RE: Request for further information BE/55/26/HH

- I confirm that the clients details are Mrs Petherick, 73 Osprey Gardens, Bongor Regis, PO22 9QQ.
- I agree to the wording change to "Ramp with galvanised handrails to front entrance including widening of the driveway"
- Revised site plan, proposed site plan and elevations are attached
- Biodiversity statement attached.

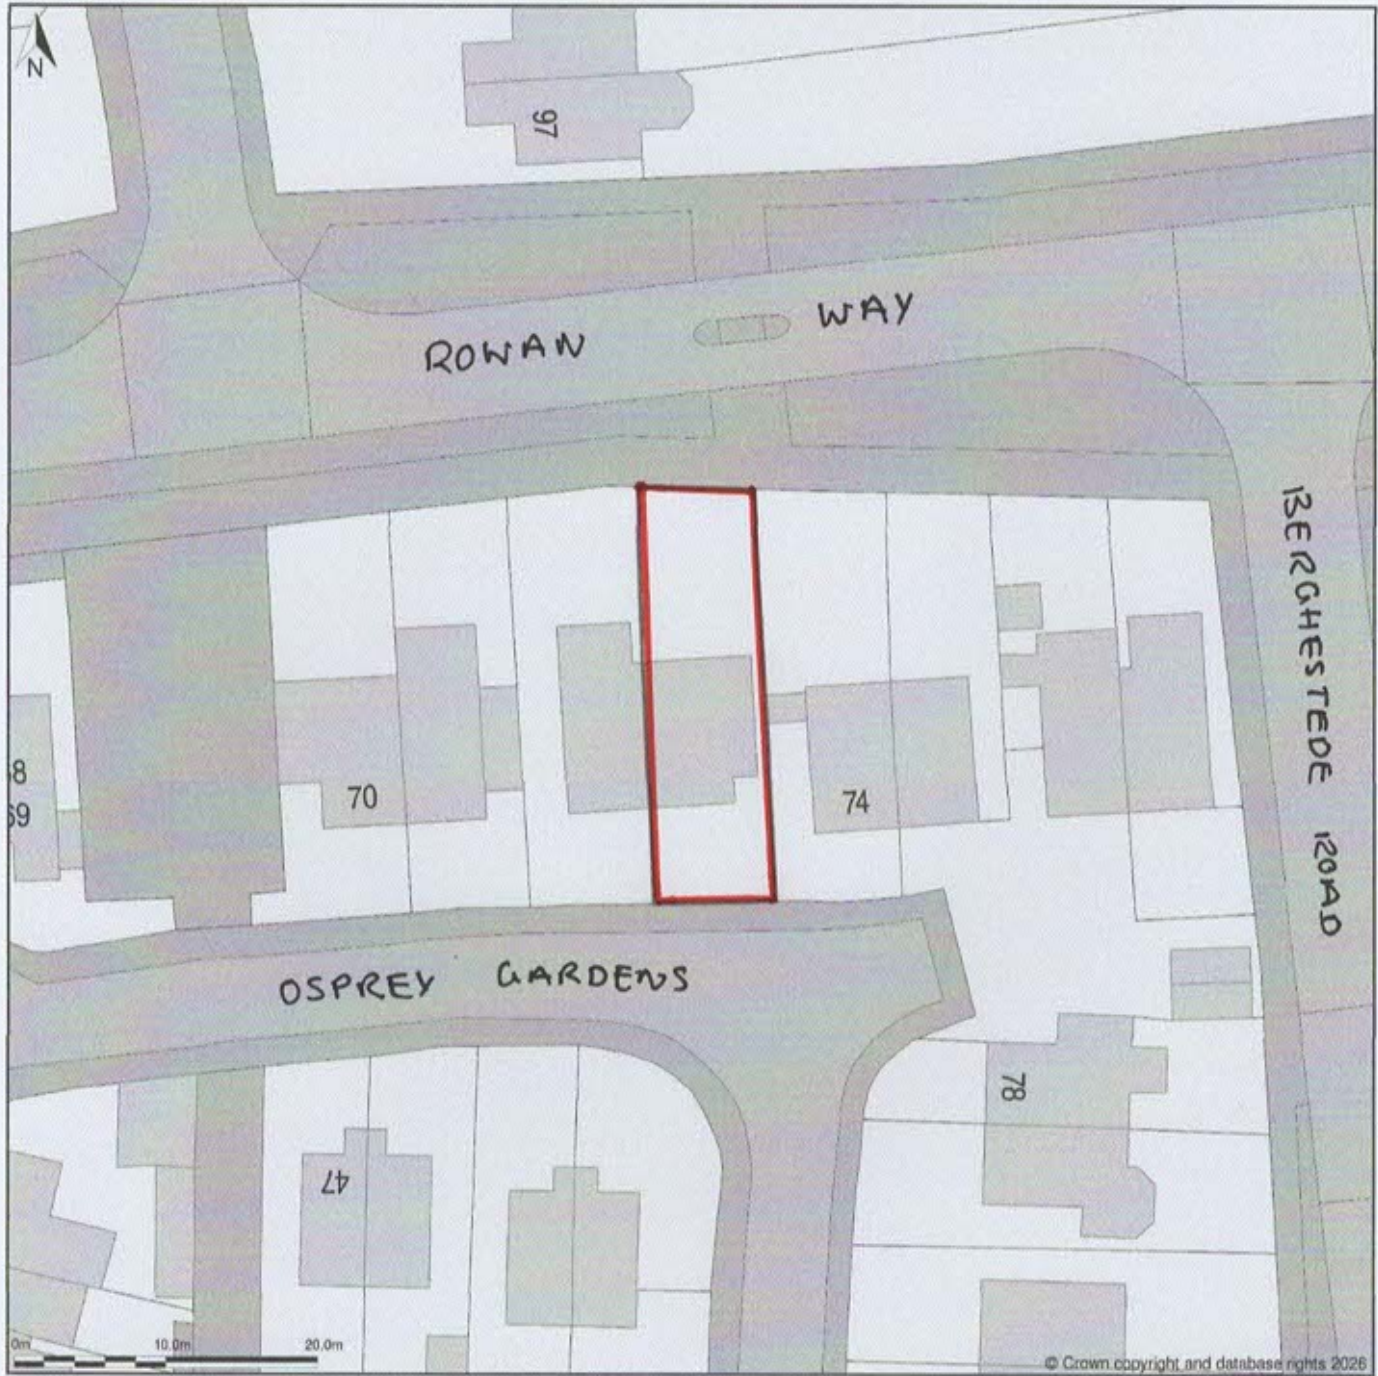
- The biodiversity enhancement statement needs to outline how the biodiversity will be improved, attached is an example
- The proposed elevation plans show the length of the ramp at 6.45m and width at 1.2m, these dimensions are inconsistent with the dimensions that are on the block plan when using a 1:500 scale. Keep in mind we work with a 0.3m tolerance.
- The application form has not been amended and so still shows that both applicant and agent names are Heather Thomas, please clarify or amend.
